**BALLYHEA NATIONAL SCHOOL
THE BOARD OF MANAGEMENT**

Response to a number of submissions made on behalf of CIE

at an Oral Hearing held at Newcastlewest

Case no. CASE N. NA04.310286

Figure 2.11: XC212 Ballycoskery Proposed Alignment

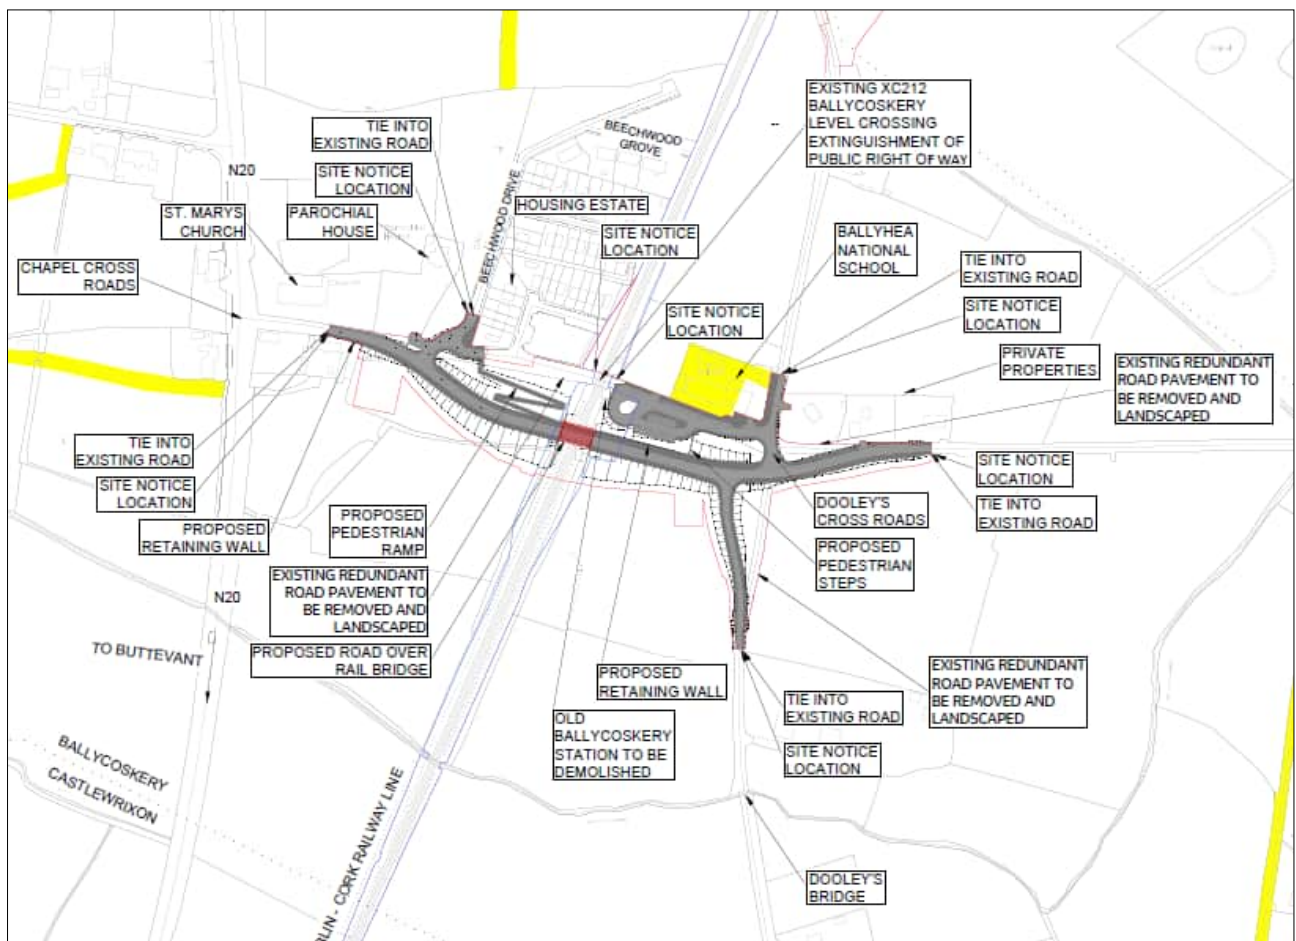
This is especially true with regard to the provision of a car park in front of the school that the Board has never requested, on whose design etc. it has not been consulted, as well as with regard its practical operation.

Thirdly, Healy at 252, p. 52 misunderstands the BOM's point with regard to the access to the school, school yards and community hall that runs along the northern boundary of the property for emergency vehicles. The point here is the access to this emergency route from the minor road running along the eastern boundary of the property and to which works are planned to be carried out. A similar point could be made for emergency access to the parochial house for which no provision has been made.
